Our ref: NO/2012/103210/01-L01
Your ref: 3/2012/0006
Date: 03 February 2012

**PROPOSED FOOTPATH/CYCLE LINK CONNECTING EXISTING PRIVATE ROAD
TO PROPOSED FOOTPATH/CYCLE NETWORK PERTAINING TO PLANNING
APPLICATION 3/2010/0719P AND APPEAL APP/T2350/A/11/2161186
HENTHORN ROAD CLITHEROE LANCASHIRE**

**PROPOSED FOOTWAY/CYCLEWAY
CROSSING PLAN**

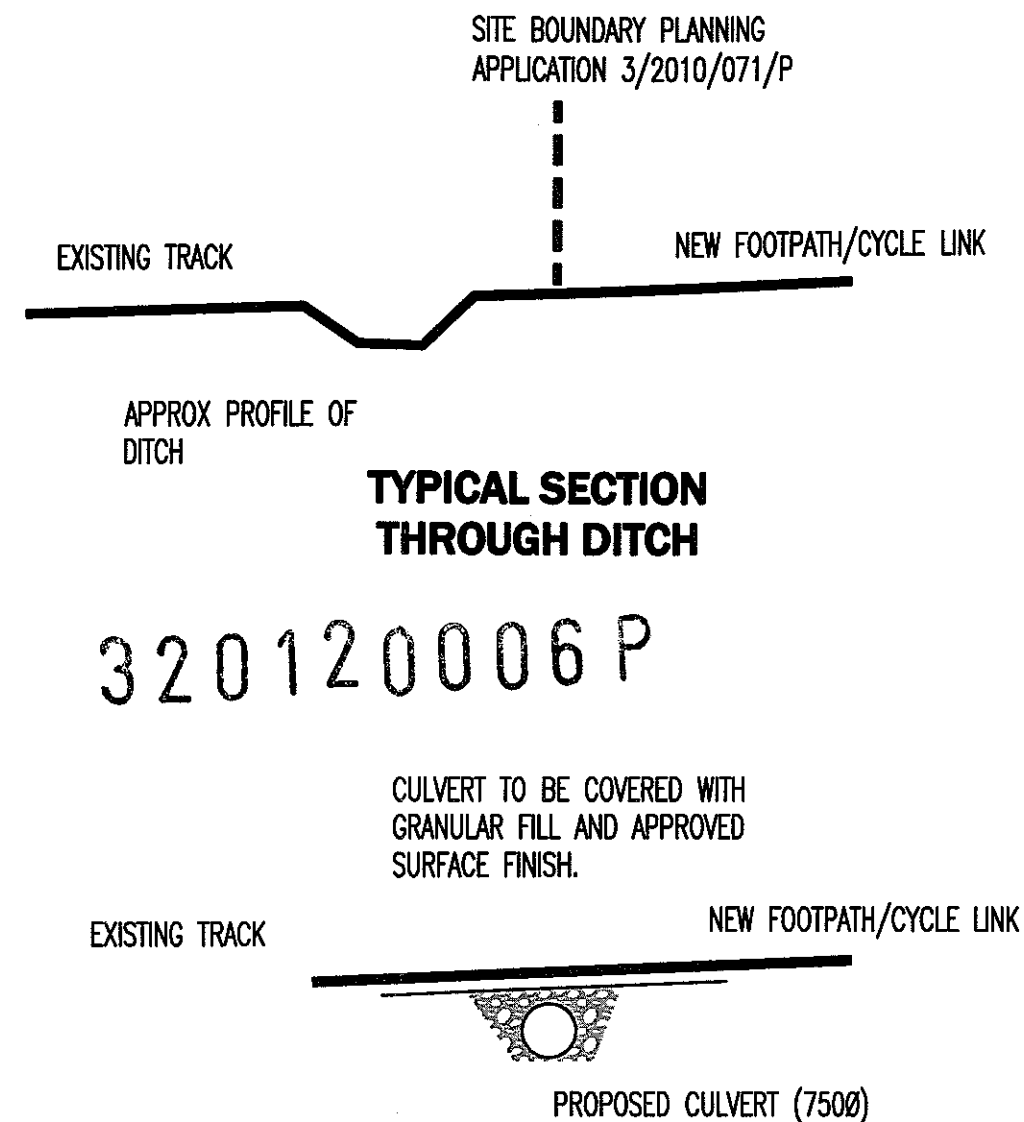
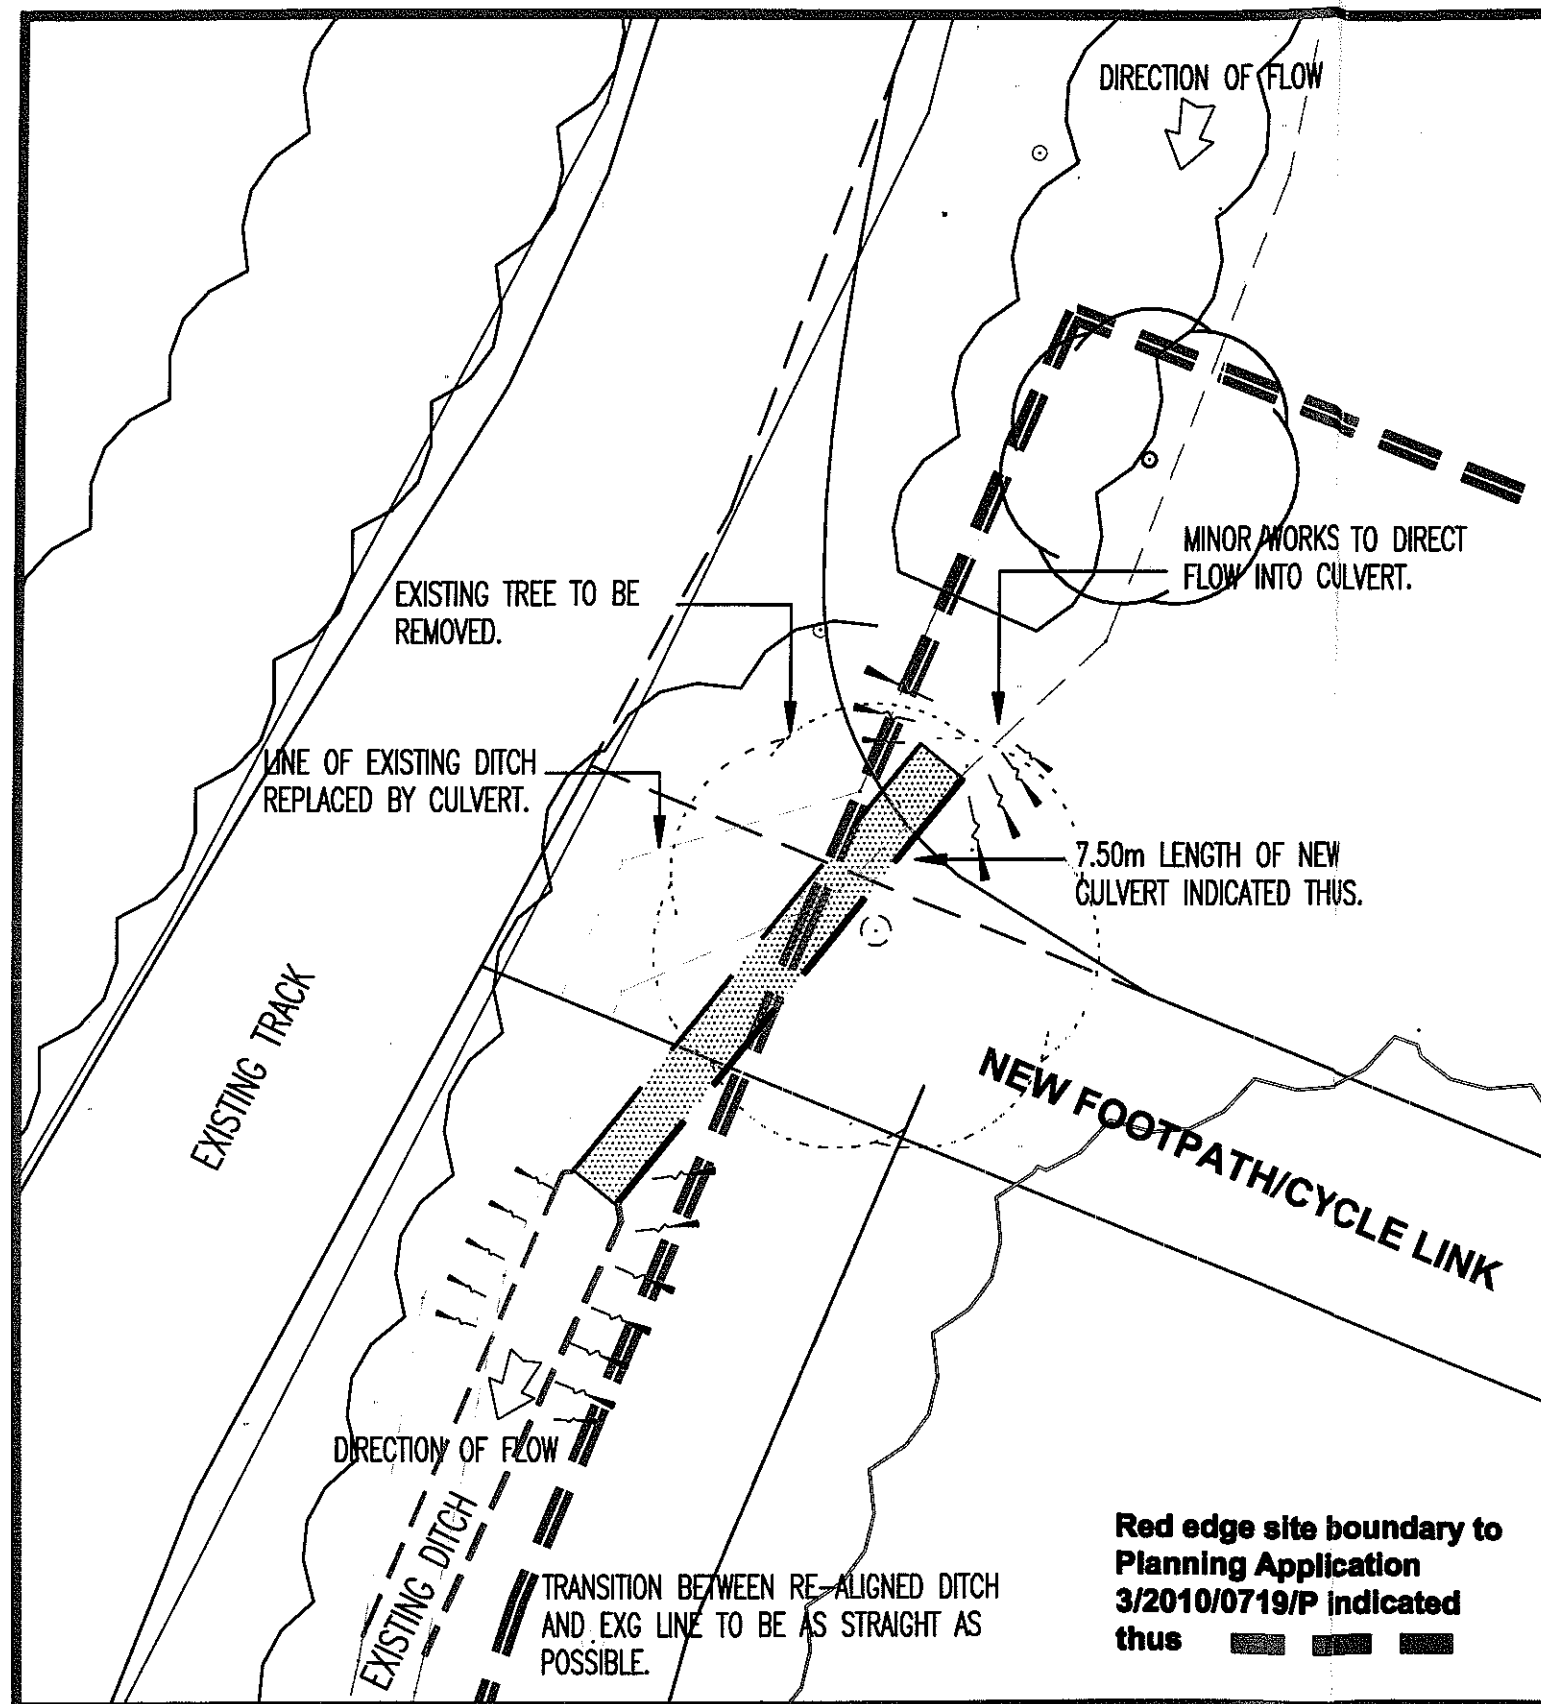
The proposed development as submitted includes the culverting of an un-named watercourse which would have a damaging impact on nature conservation. We are unable to adequately assess the impact of this proposal as the length of culvert has not been stipulated and therefore we cannot comment on the necessary mitigation.

The applicant has also not yet demonstrated that consideration has been given to alternative structures, such as an open span bridge or wooden boards, and that there is no reasonable practicable alternative.

It would be preferable if the new culvert was at least 1050mm diameter so that it could be accessed, with the invert level set 150mm below existing stream bed level.
